**From:** Nolan, Chris [<mailto:Chris.Nolan@lancashire.gov.uk>]  
**Sent:** 13 September 2017 10:39  
**To:** Robert Major; planning  
**Cc:** LHS Customer Service  
**Subject:** D3.2017.0825 - Causeway Farm Longsight Road Balderstone

Planning Application No: 3/2017/0825  
Grid Ref: 364450 431585  
Proposal: Conversion of existing agricultural building into cattery.  
Location: Causeway Farm Longsight Road Balderstone BB2 7HZ

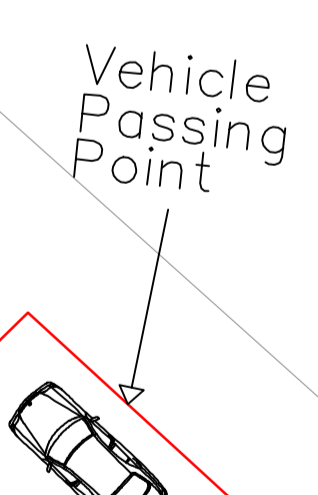
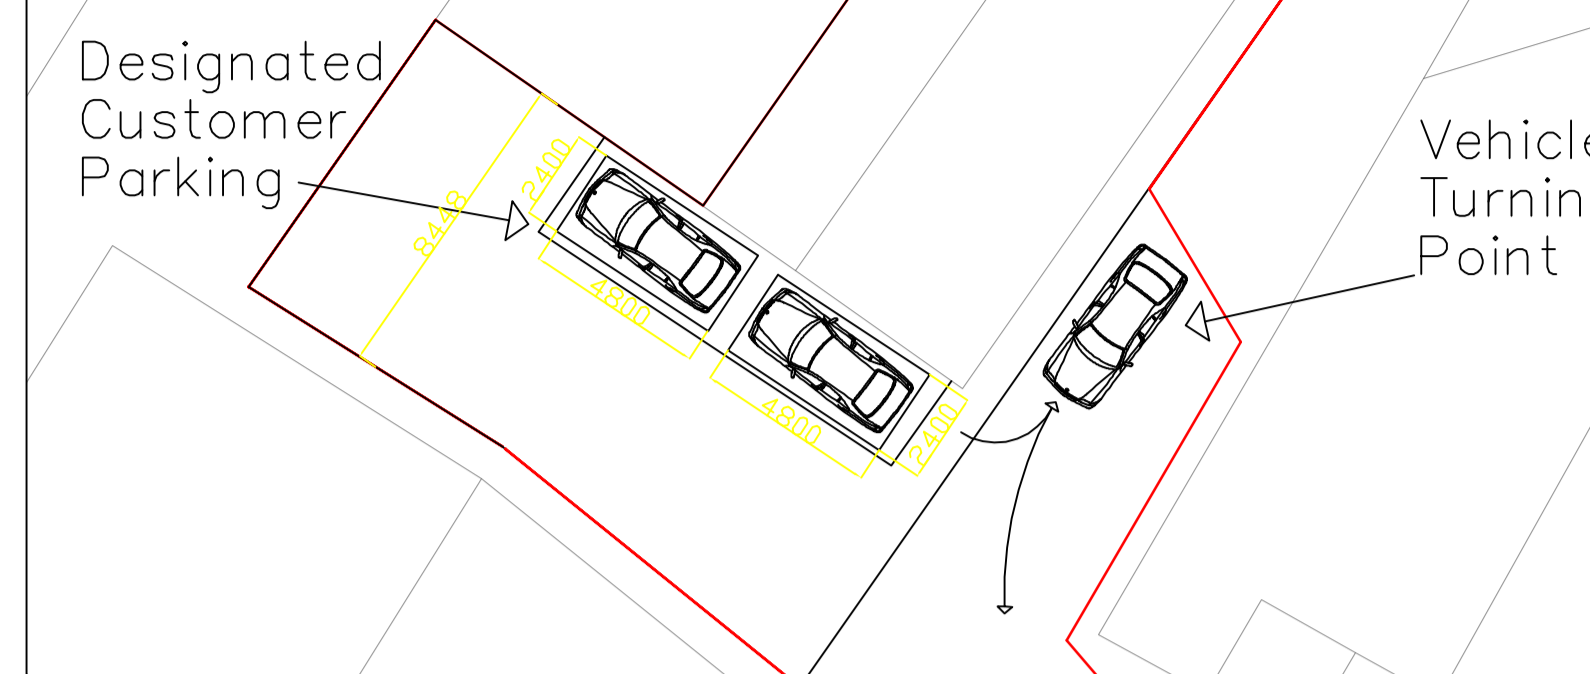
1. The plans indicate that there are two existing parking spaces that will be retained. There is no mention that these spaces will be specifically for customer parking and the spaces indicated seem to be on a through route within the farm complex. I would like plans that indicate two allotted parking spaces for the customers. These would need to be at a scale not larger than 1:200 and dimensioned indicating spaces of a minimum of 2.4m X 4.8m.

2. I am concerned that customers will be visiting the site to deliver or pick up their pets. As the access to the farm is via a single track lane directly off the A59 Longsight Road I would be looking for measures at the entrance that would remove any situation where vehicles are reversing onto out of the entrance. I would suggest that this could be addressed by forming a passing place sufficient for two cars just inside the gates. This would allow vehicles to pass rather than customers reversing on to the main road to allow an vehicle to exit the farm.

1. Scaled and dimensioned plans indicating parking arrangements for customers are supplied and the agreed provision is maintained for the period that the building is used for a cattery. Reason to ensure that there is a sufficient safe parking for customers.

2. The layout of the farm shall include provisions to enable vehicles to enter and leave the highway in forward gear and such provisions shall be laid out in accordance with the approved plan and the vehicular turning space shall be laid out and be available for use before the redundant building is used as a cattery and maintained thereafter for the period of this use of the building. Reason: Vehicles reversing to and from the highway are a hazard to other road users.

3. A suitable passing place is formed on the access road in close proximity to the gate off Longsight Road so that the need to reverse out of the gate under any circumstances is eliminated. This facility will be retained for the period that the building is used as a cattery. Reason: Vehicles reversing to and from the highway are a hazard to other road users.
